Application by AQUIND Limited for an Order granting Development Consent for the AQUIND Interconnector Project (PINS reference: EN020022)

Submission in relation to Deadline 3 of the Examination Timetable

**The Owners of Hillcrest - Mr. Michael Jefferies and Mrs. Sandra Jefferies, Registration Identification Number: 20025044
Submitted in relation to Deadline 3 of the Examination Timetable**

Prepared by Ian Judd and Partners LLP on behalf of the Landowner

Figure 15.49: Indicative Landscape Mitigation Plan Option B(1) (south)

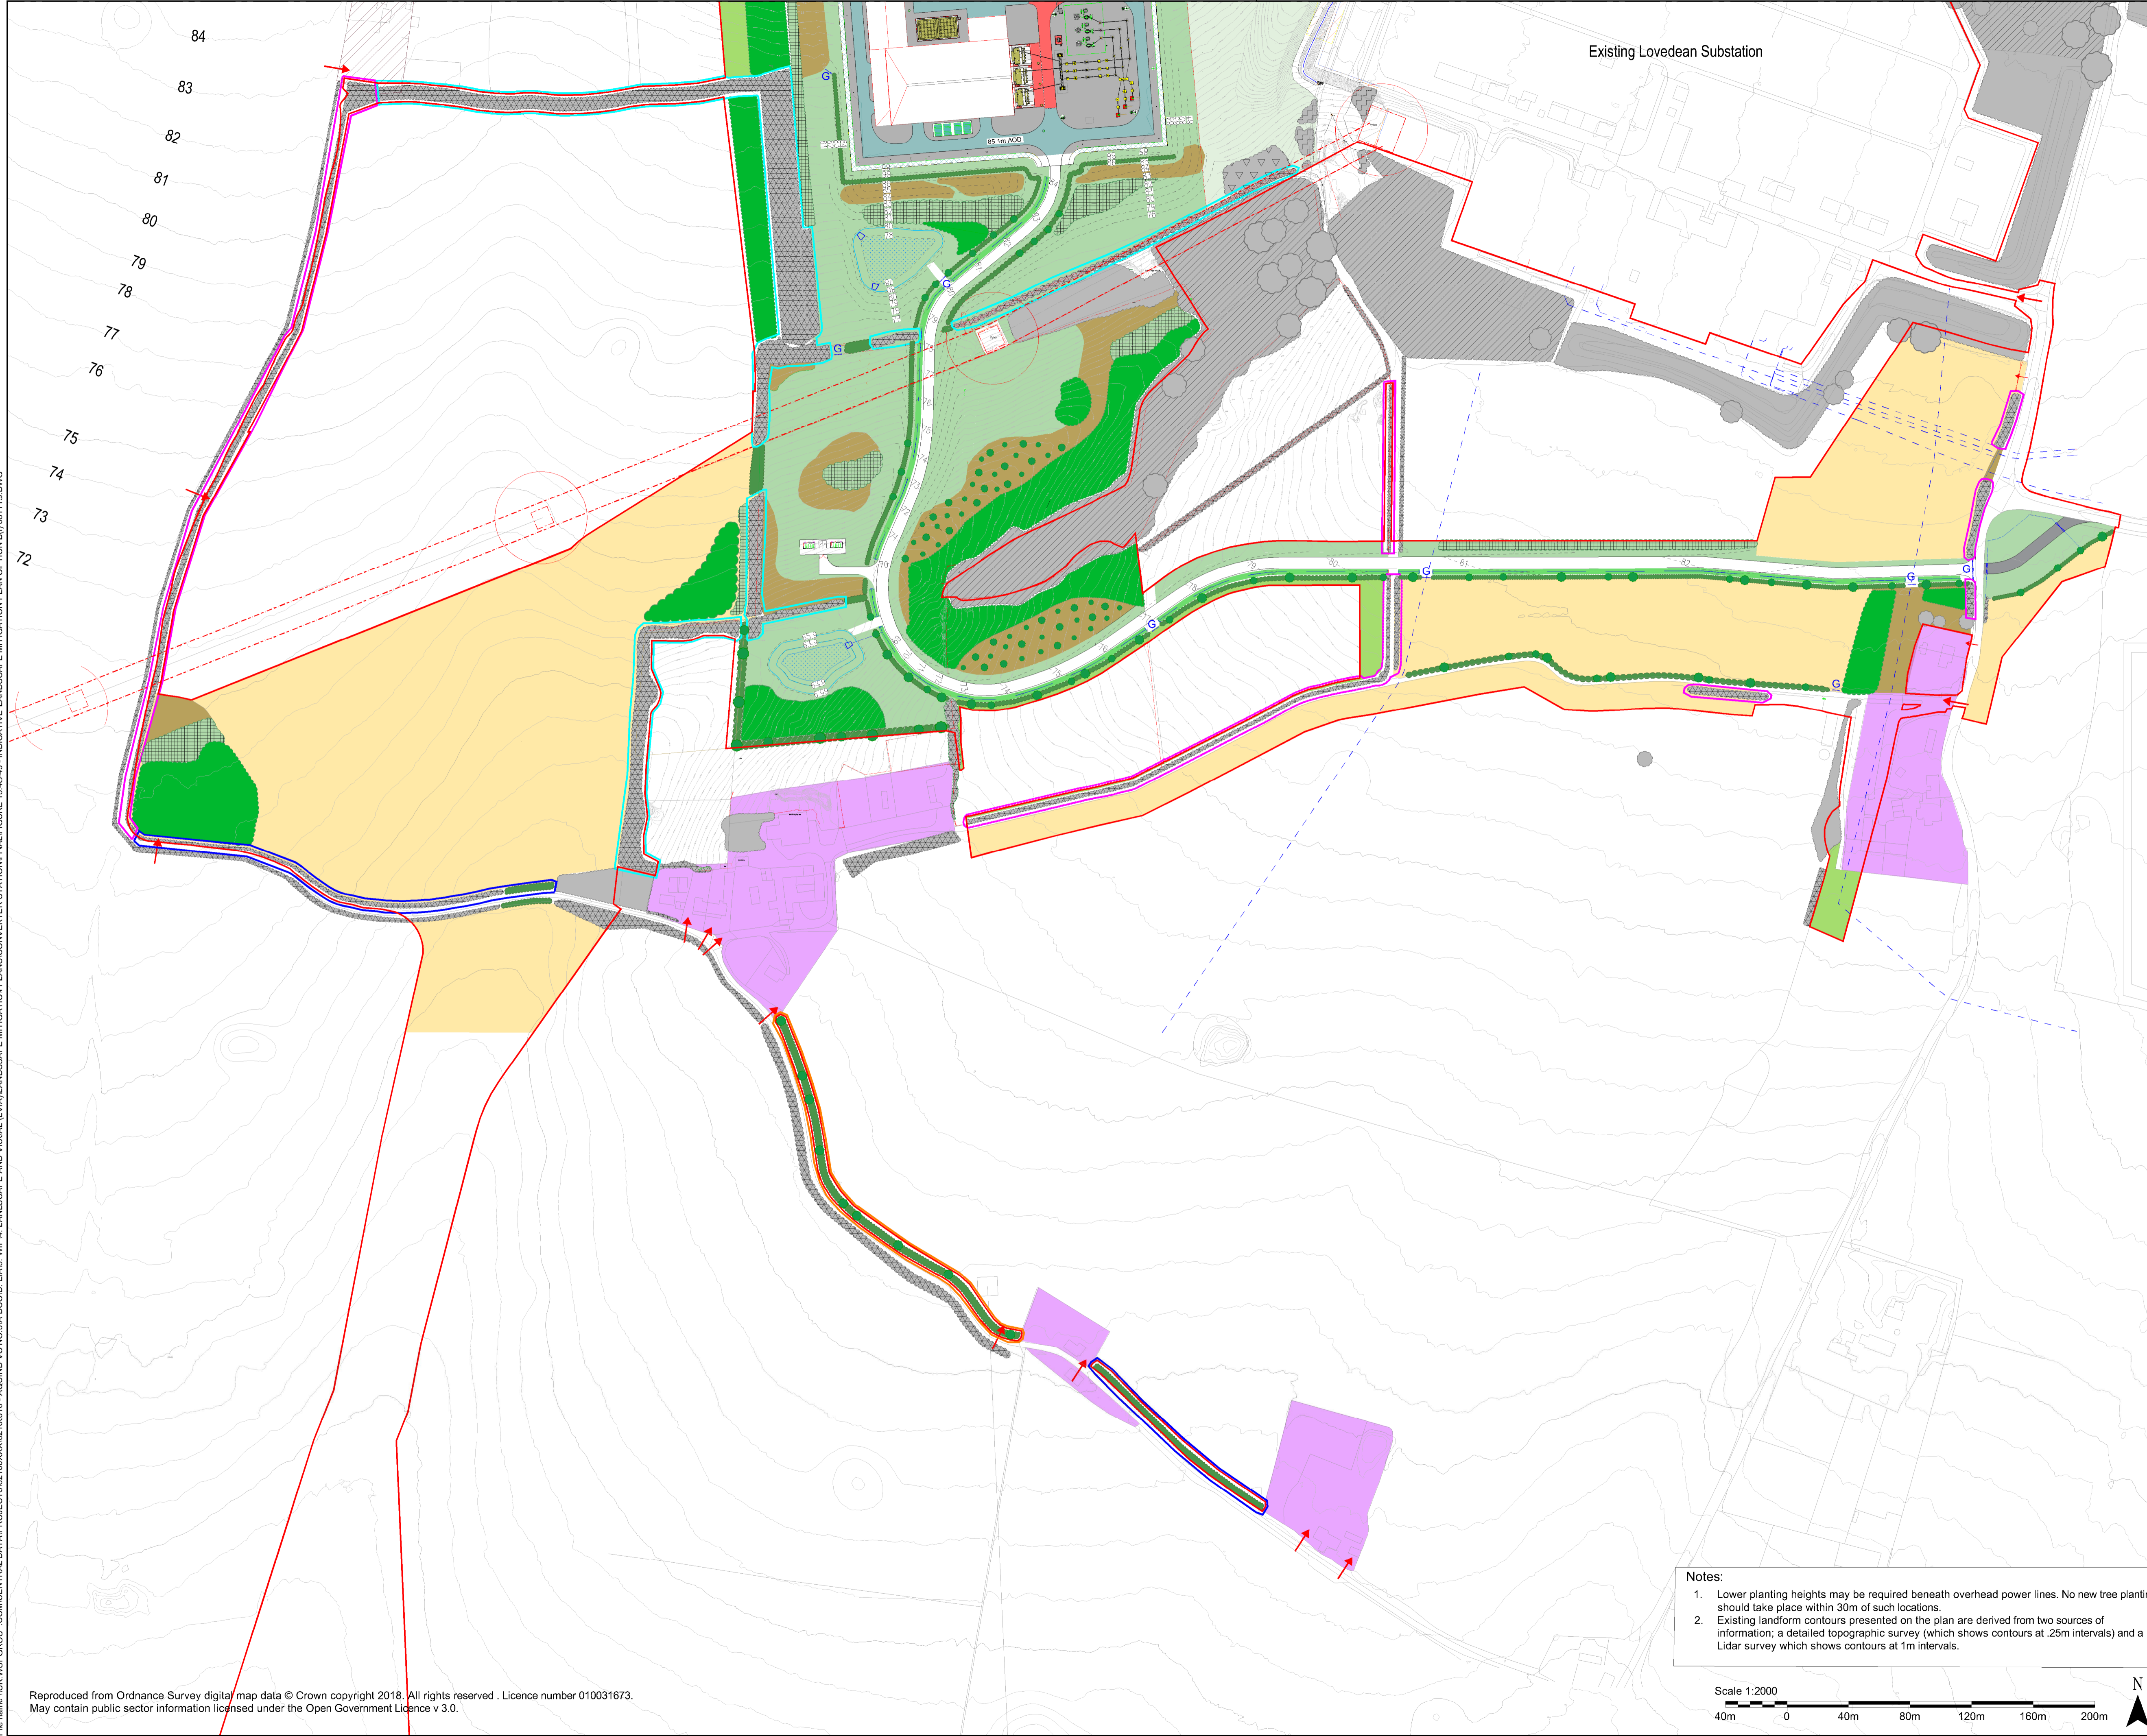
<p>5.3.7 The Promoter has also failed to produce an Indicative Landscape Mitigation Plan in relation to Option B(ii).</p>	<p>These are shown on the Indicative Landscape Mitigation Plans for Option B(i) (APP-281) and B(ii) (REP1-137).</p>	<p>Much of Plot 1-23 will remain Existing Recreational Area and proposed scrub and will offer little landscaping value. Why are compulsory acquisition rights sought on this land?</p>
<p>5.3.8 The Promoter will not need to own the freehold to the land within plot 1-23 that is only to be landscaped because it will also be protected by Article 23 of the draft DCO if the Promoter only has landscaping rights over that land.</p>	<p>Any third party rights over these areas would be significantly constrained by the potential presence of the Converter Station Site (for Option B(i)) and the landscaping which is to be located on this land in the event of either option, meaning access and enjoyment of the land will not be possible (for both options) once the landscaping to be provided in connection with the proposals is in situ. It is therefore not considered that the acquisition of landscaping rights only over these areas (noting that landscaping rights are proposed over existing landscaping rather than landscaping which is to be provided in connection with the Proposed Development) would be appropriate, as the land in its current form would no longer be of practical use save for serving its landscaping function in connection with the Proposed Development. Furthermore, it is necessary to acquire the freehold of the entirety of these areas in much closer proximity to the Converter Station to prevent third party access for safety and security</p>	<p>Other than safety and security, the Applicant has not address the issue raised. With no form of safety or security fence around the freehold site, it remains unclear how the ownership of the entirety of Plot 1-23 aids safety or security of the Converter site.</p>

related reasons during the construction and operation of the Proposed Development.	
5.3.7 The Promoter has not demonstrated that it has a clear idea of how it intends to use the land which it proposes to acquire.	Plot 1-23, together with Plots 1-20, 1-29 and 1-32 will accommodate the Converter Station, the Telecommunications Buildings, two attenuation ponds, the Access Road and significant areas of landscaping.	This is very misleading, as neither the converter station, Telecommunications Buildings or Attenuation ponds or Access Road will be located on Plot 1-23. It appears the land is solely required for Landscaping. Why can Landscaping rights not be sought?
